DEVELOPMENT REVIEW BOARD  
TRANSPORTATION DEVELOPMENT

DRB Project Number: 1000032  
University of Abq Urban Center

SUBJECT: Sketch Plat

<b>DRB Case No:</b>  1000032	<b>Date:</b>  06/01/16	<b>Item No:</b>  #7
<b>Zone Atlas Page:</b>  G-11	<b>LOCATION: Lot X-1-A1 University of Albuquerque Urban Center</b>  <b>Coors and St. Josephs Dr. NW</b>	
<b>Request For: 16DRB-70187 Sketch Plat</b>

SITE CONDITIONS
TRACTS X-1-A2 AND X-2-A
WITHIN
UNIVERSITY OF ALBUQUERQUE URBAN CENTER
THE TOWN OF ALBUQUERQUE GRANT
IN
SECTION 2, TOWNSHIP 10 NORTH, RANGE 2 EAST
NEW MEXICO PRINCIPAL MERIDIAN
CITY OF ALBUQUERQUE
BERNALILLO COUNTY, NEW MEXICO
OCTOBER, 2016

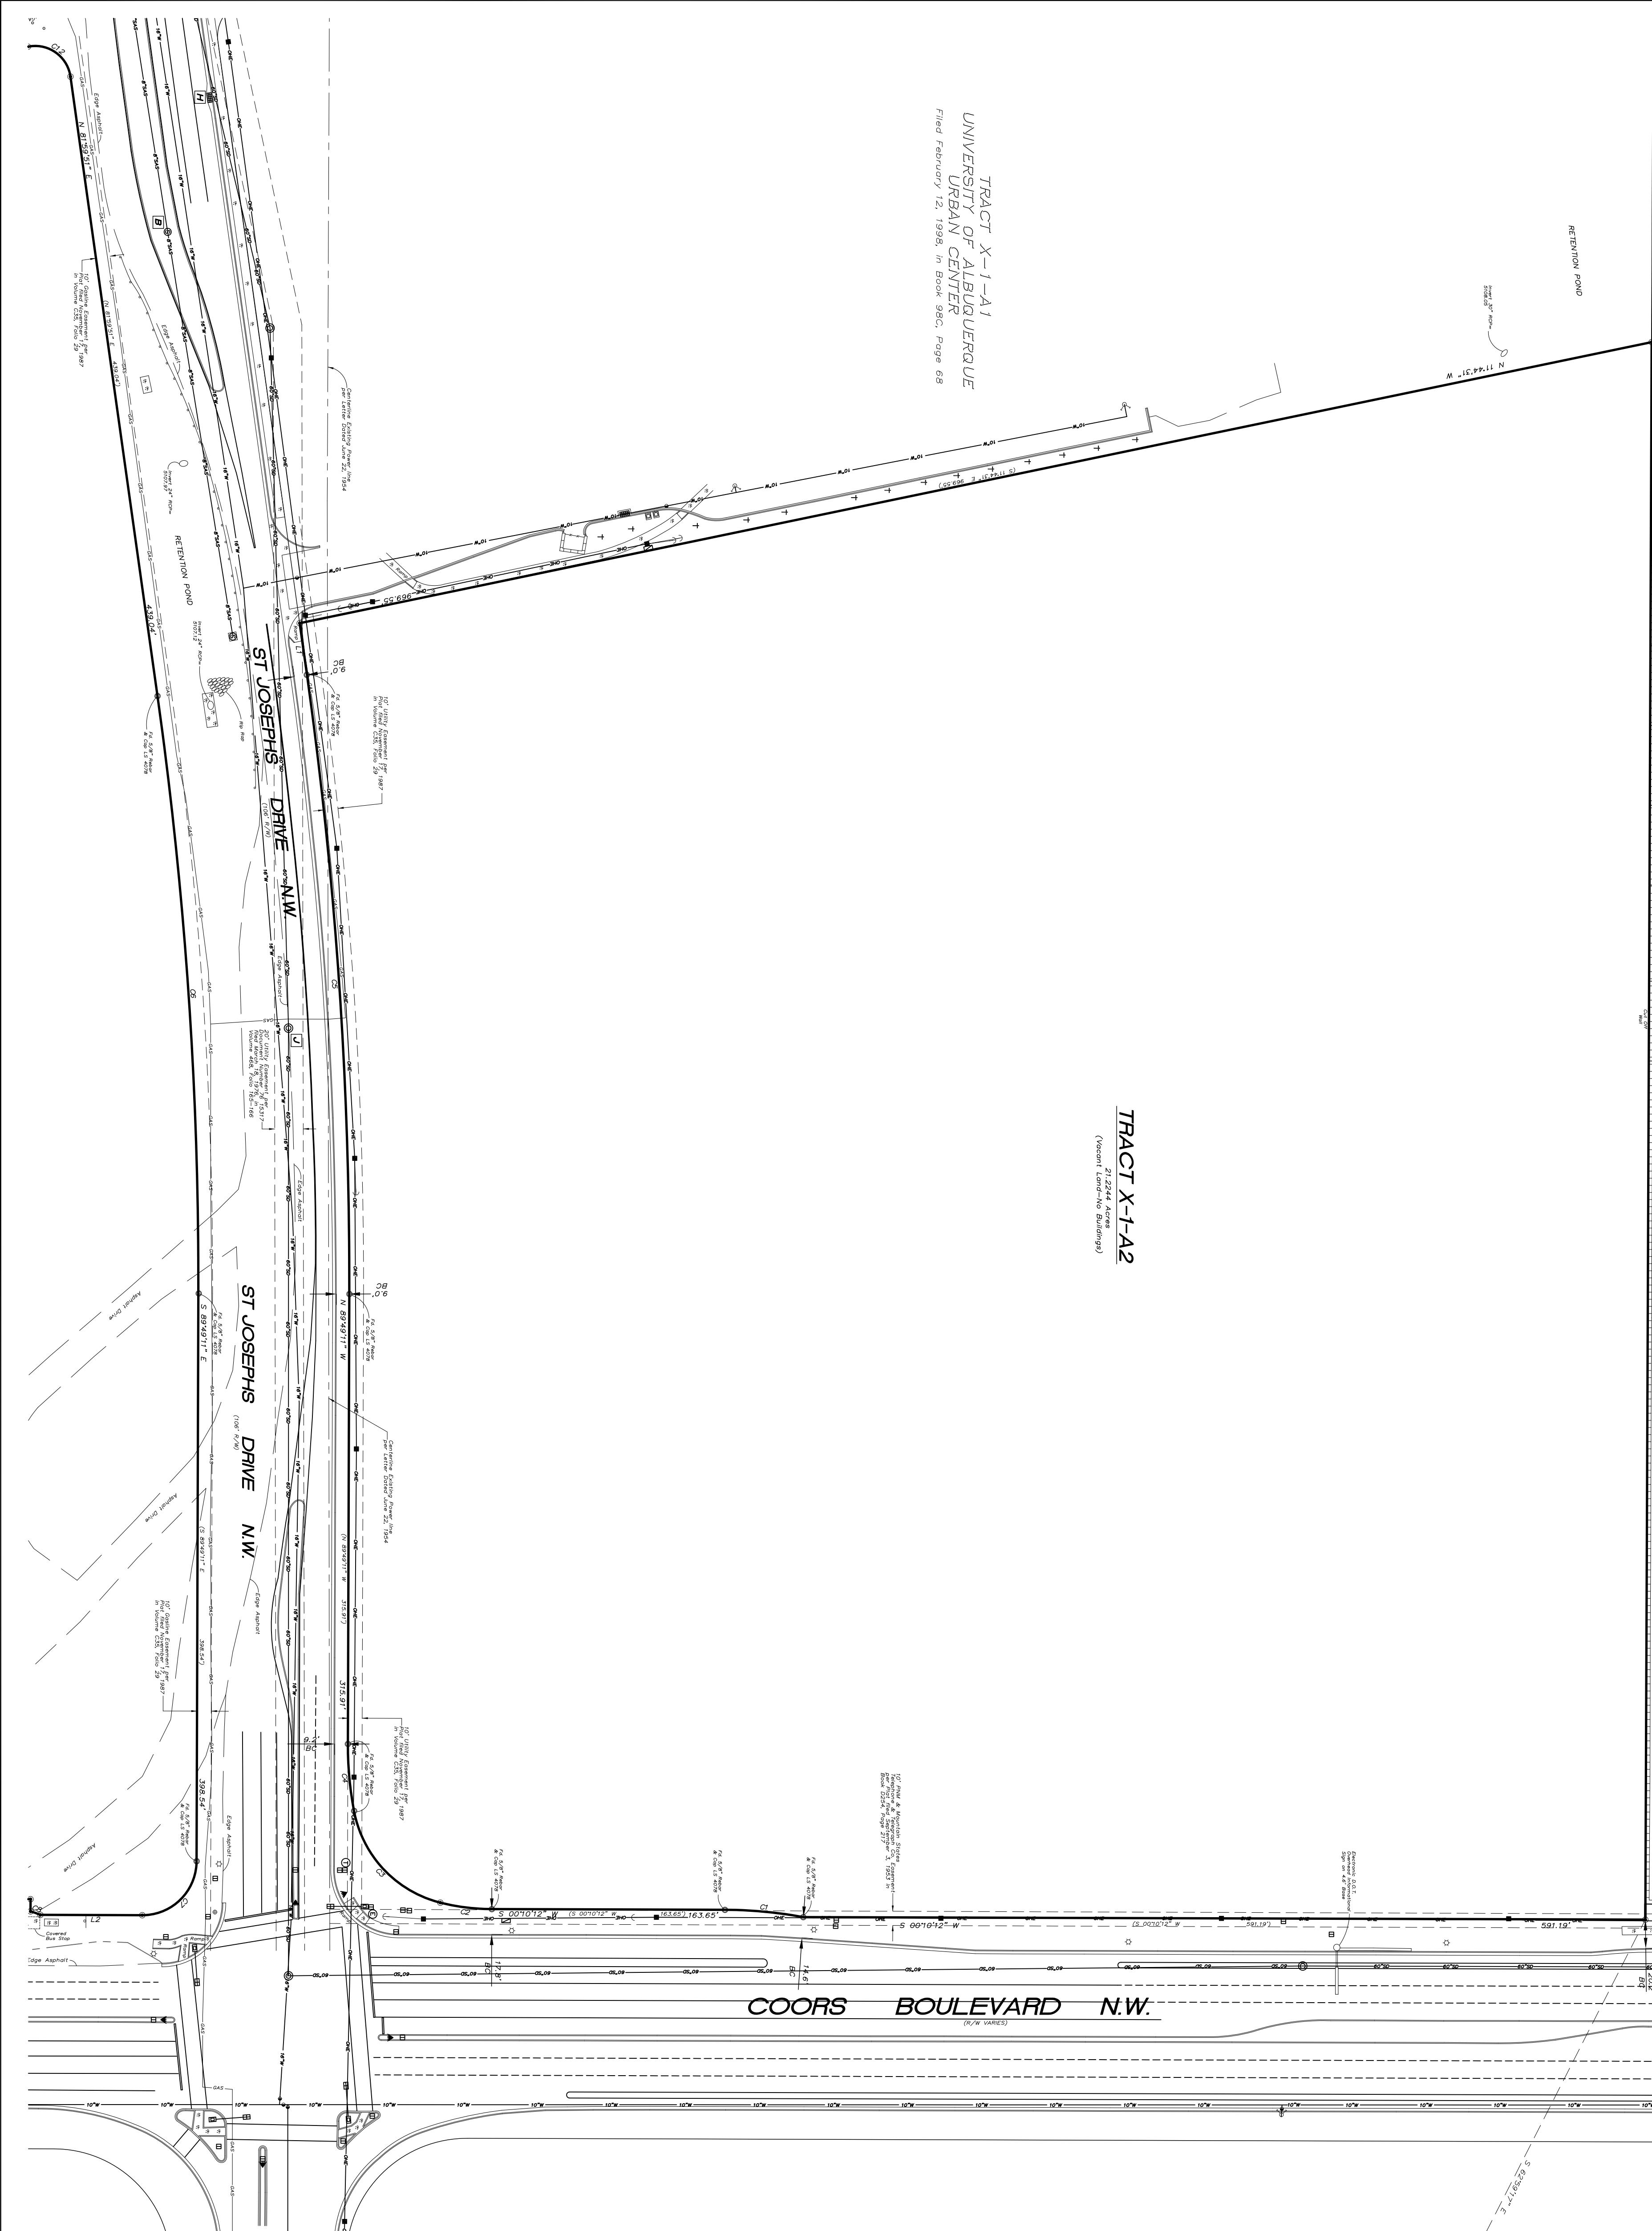
1. Provide an exhibit showing the location and width of sidewalk and defining the distance from back of curb to the property line. Right of way dedication may be required.
2. If future development is not going to be submitted to DRB, a TCL (Traffic Circulation Layout) will be required before building permit.
3. For final plat, any access easements need to be shown with all beneficiaries and maintenance responsibilities listed.
4. The Traffic Impact Study (TIS) needs to be approved prior to approval of the infrastructure list.
5. If the project will be phased, please provide a phasing plan at building permit.
6. Infrastructure is required to bring the transportation facilities in this area up to current standards.

Per the Subdivision Ordinance, platting must conform to an approved Site Development Plan (EPC). It appears the area around the access easement in the eastern portion of proposed Lot 10 would be better served by being incorporated into proposed adjacent tracts. Additionally, screening for the residential use on the north boundary may be better served with an alternate access layout.
